**SEAS summary of outstanding issues on Applicants D4 responses
following ISH2 and on ExQ2**
TRAFFIC & TRANSPORT

SEA LINK: EN020026
DEADLINE: 5 – 10 March 2026

Summary of outstanding Traffic and Transport issues following ISH2 and ExQ2

Plate 2.1 Section of Benhall Bridge

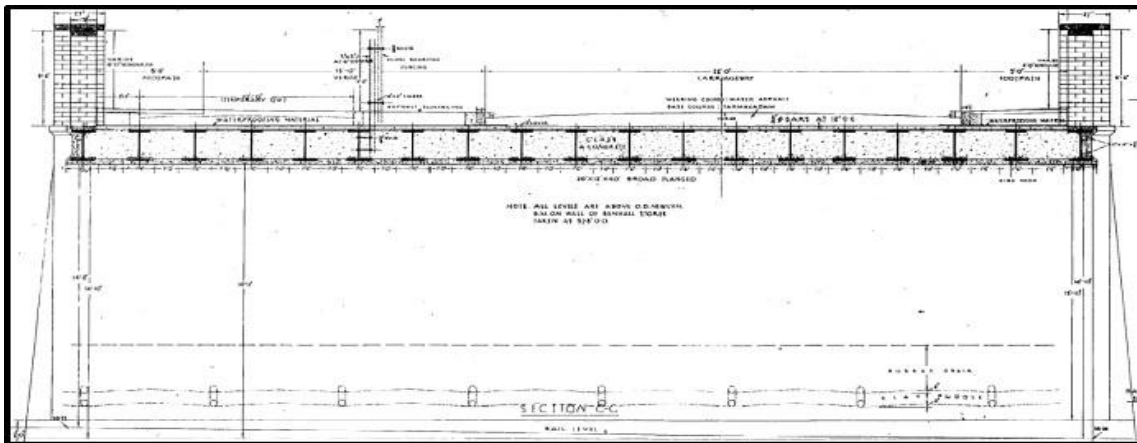
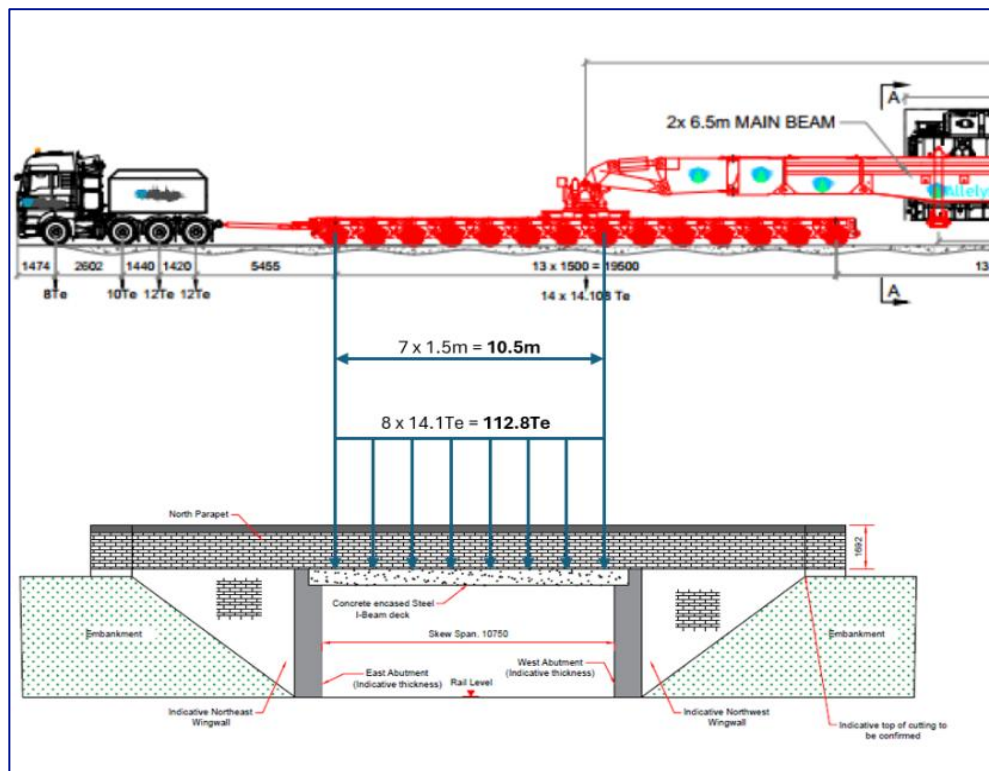
5.1 The applicant concludes a maximum of 28 days would be required to repair the bridge to satisfactory standards. Despite the clear need for inspections and assessment to assess the repair work required. It seems **highly unlikely that a construction programme can be identified** when the works haven't been identified.

5.2 Similarly, NGET acknowledge that possessions are completely at the discretion of Network Rail and that the applicant will have no control over that – this adds substantially to the uncertainty of bridge closures for longer periods of time. Alternative options to build a mini bridge alongside it are clouded with similar uncertainties.
